A/87/18/PL OBJECTION

I am writing to object to A/87/18/PL for the following reasons.

Site Plan (1:500)

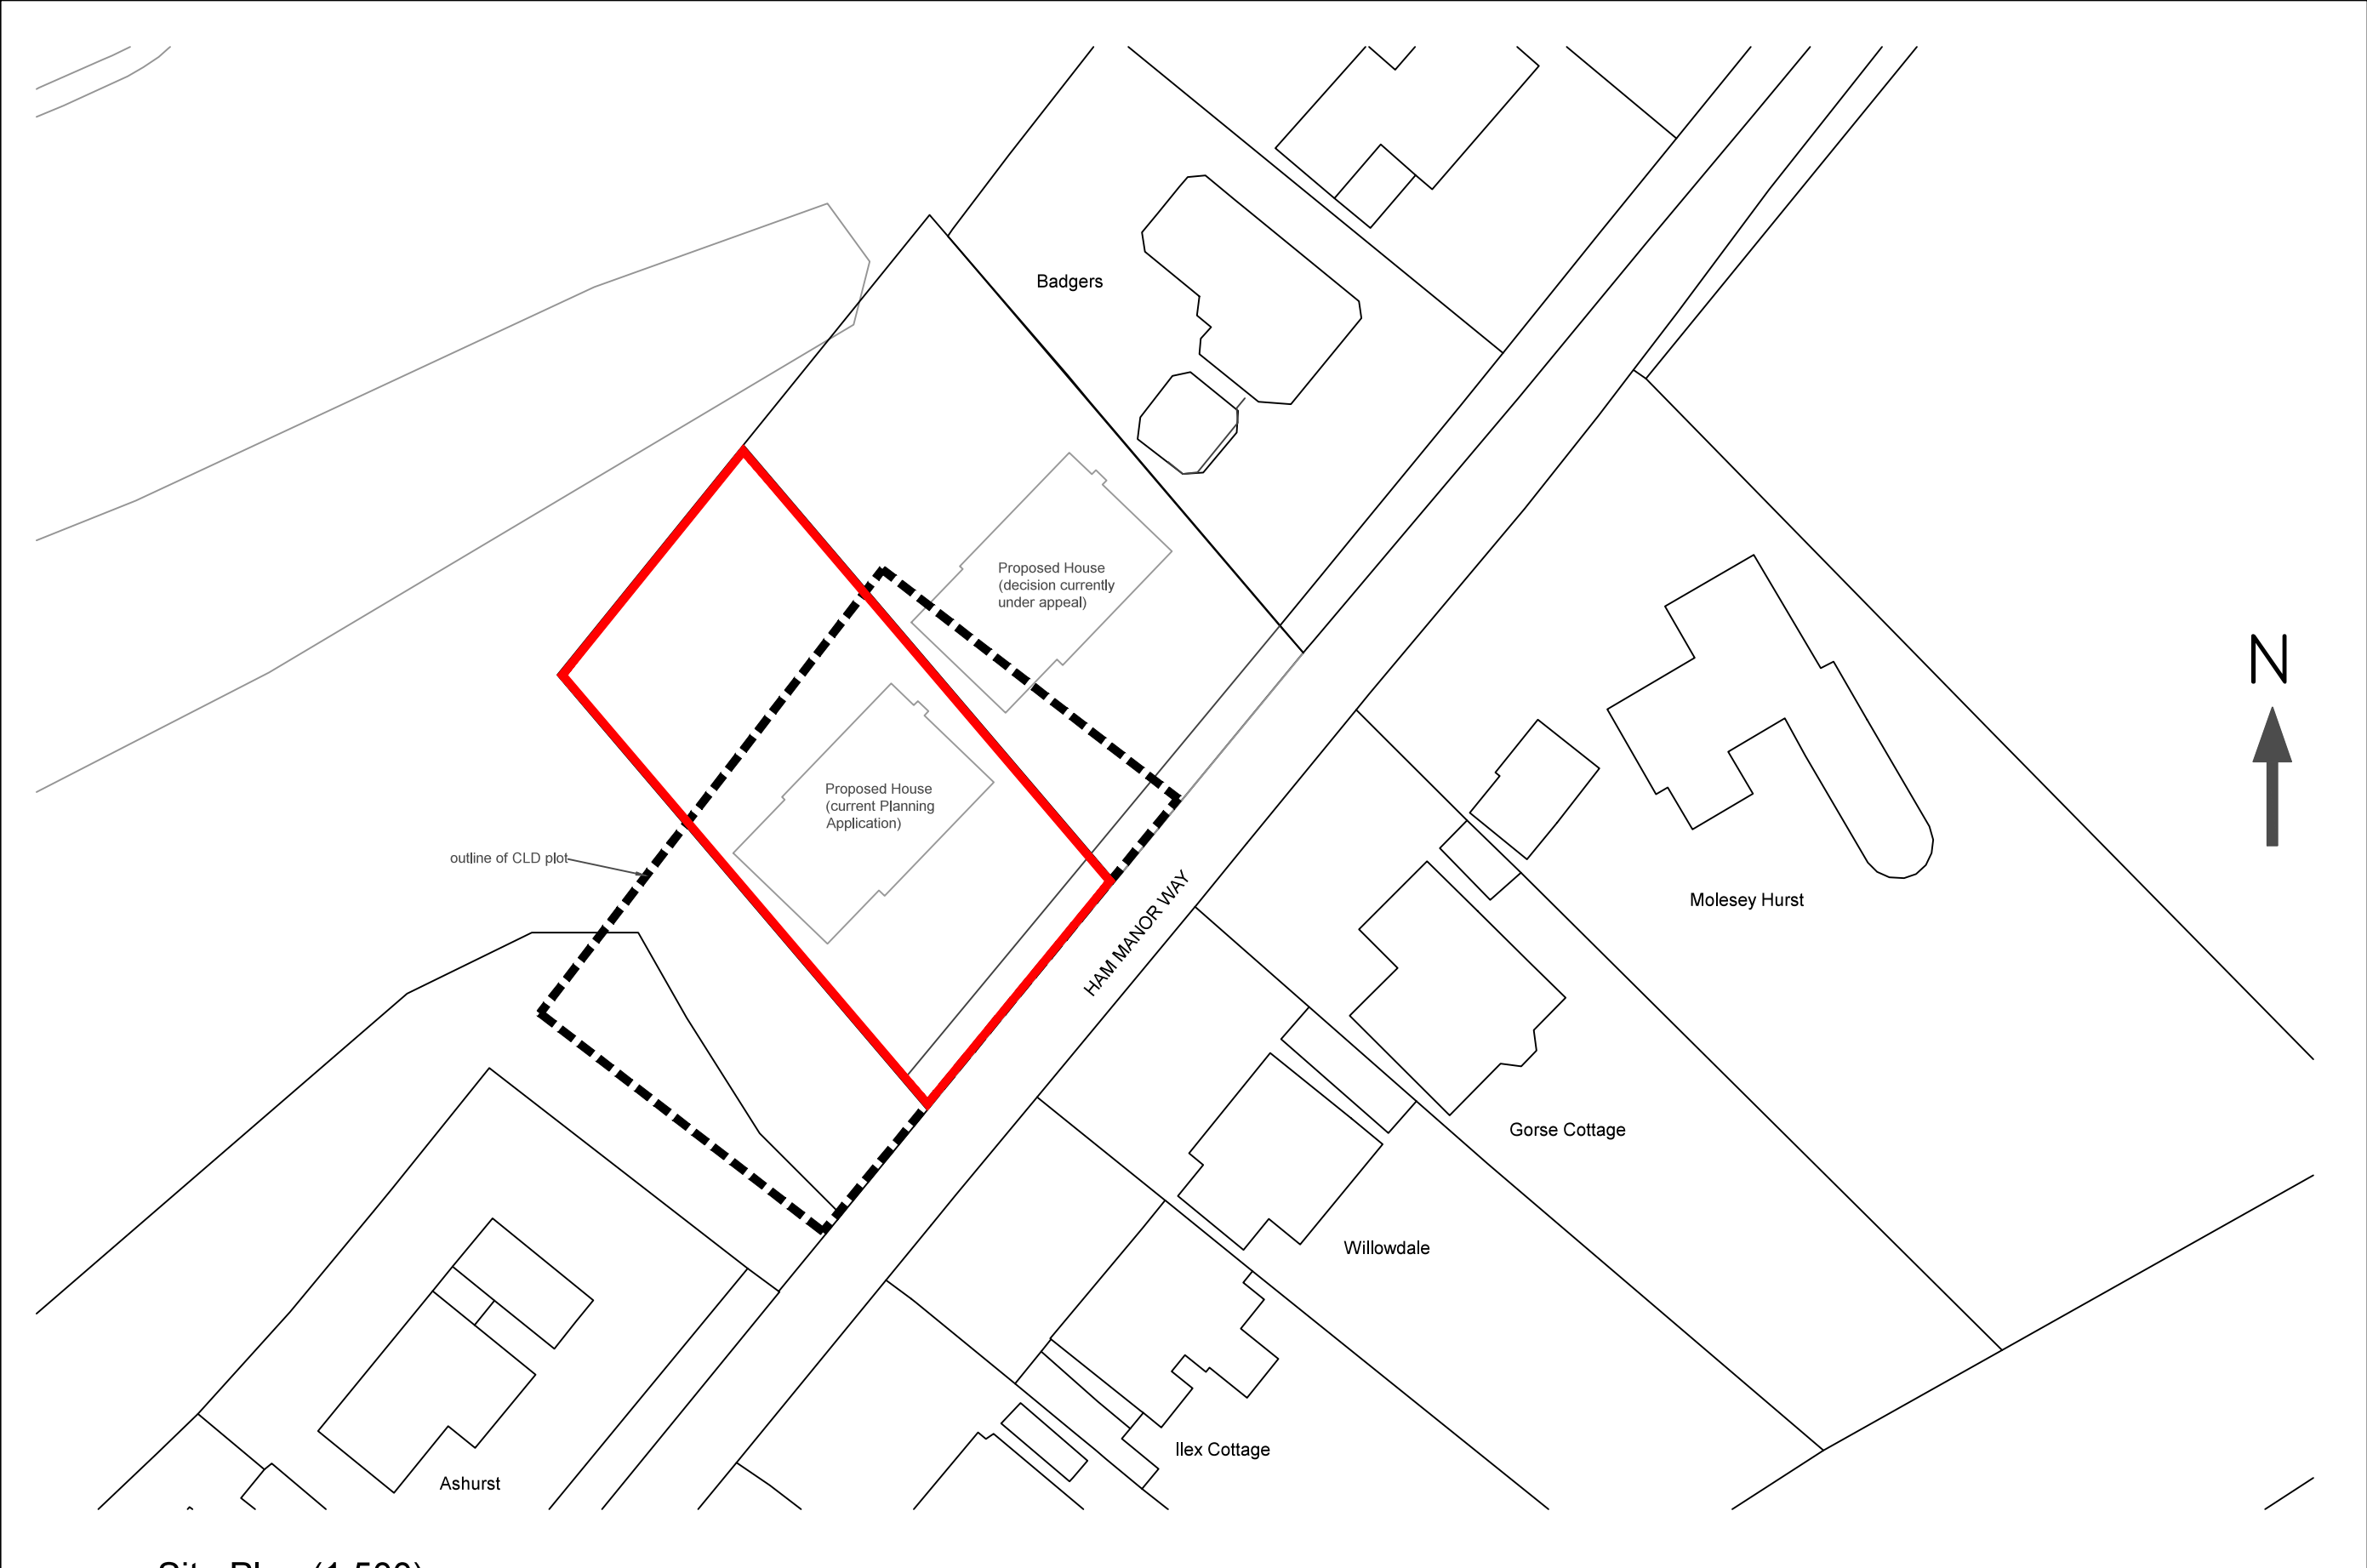
The applicant has permission to build two properties on the CLP space (A/212/17/CLP), A/87/18/PL application shows a large portion of the plot outside the CLP area as shown on Block plan dwg. 1131.203. Therefore no development should be allowed outside the CLP area as it protected Local Green Space.

Street Elevation (1:200)

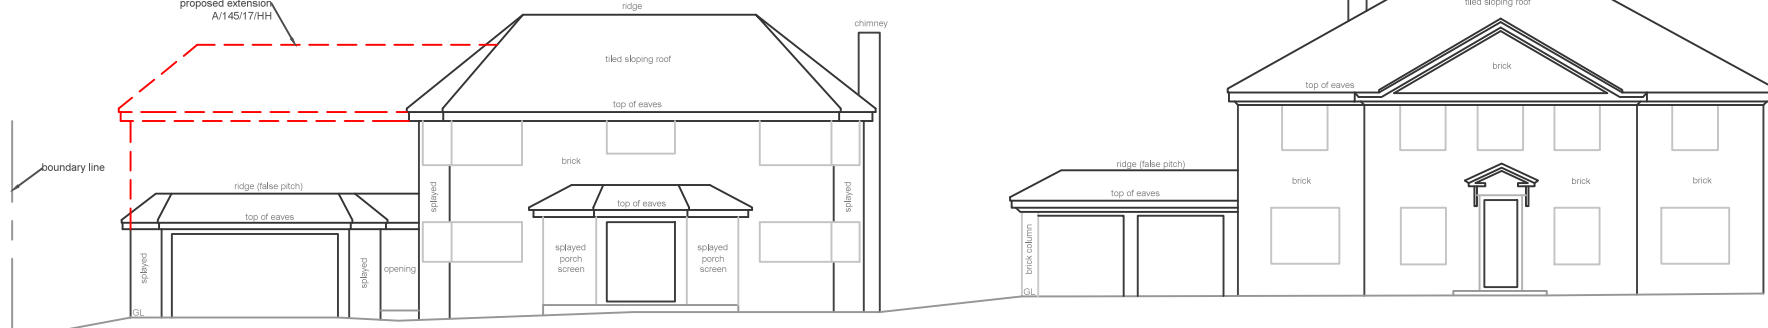
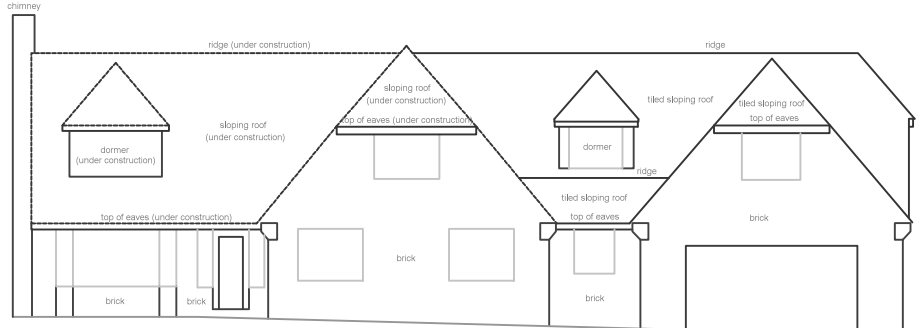
The applicant proposes ONLY ONE large single dwelling with gaps either side, such a stand alone property will be out of context with the street scene. In the area of the road housing is typified by chalet bungalows.
